**KIRKLEES METROPOLITAN COUNCIL
INVESTMENT & REGENERATION SERVICE**

DELEGATED DECISION TO DETERMINE PLANNING APPLICATIONS

Reference No:	2026/62/90118/W
Site Address:	26, Swallow Lane, Golcar, Huddersfield, HD7 4LU
Description:	Installation of replacement door and frame (Listed Building within a Conservation Area)
Recommending Officer:	Joshua Merriman

Officer Report – 2026/90118

TITLE: FLAMEBREAK CORE
CROSS SECTION

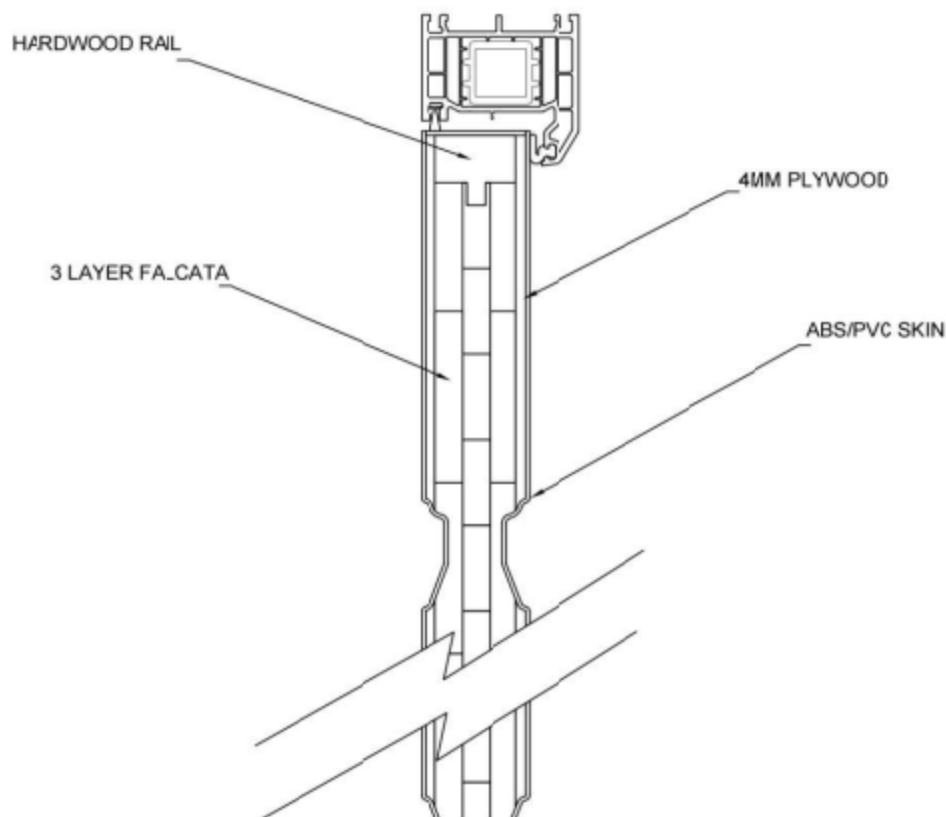
KC Conservation & Design (Informal) – The use of a composite door on a Listed Building is unacceptable as it significantly harms the historic character of the building and surrounding Conservation Area. Only a matching replacement (timber) would be considered acceptable in this case.

The replacement door is a composite material and would be at odds with the historical authenticity and visual integrity of the building. Listed buildings are protected to specifically to preserve their original features, materials and craftsmanship. Due to the surface texture, proportions of paneling there would be a noticeable visual difference. In replacing the door the works would detract within the street scene and from the character of the conservation area.

The use of modern materials would appear unsympathetic and detract from the character and appearance of the building undermining the special historic interest contrary to Policies LP1, LP2, LP24, and LP35 of the Kirklees Local Plan, and Policies within Chapter 12 of the National Planning Policy Framework.

1. The replacement door with a composite door, because of its modern materials, detailing and appearance would fail to preserve the character and appearance of the listed building. The development would result in the loss of traditional fabric and would introduce an incongruous feature that is not sympathetic to the building's historic significance and would also detract from the street scene. As such the works result in harm to the special architectural and historical interest of the designated heritage asset and Golcar Conservation Area, contrary to the statutory duty under Section 72 of the Planning (Listed Building and Conservation Areas) Act 1990, Chapters 12 and 16 of the National Planning Policy Framework, and Policies LP1, LP2, LP24, and LP35 of the Kirklees Local Plan.
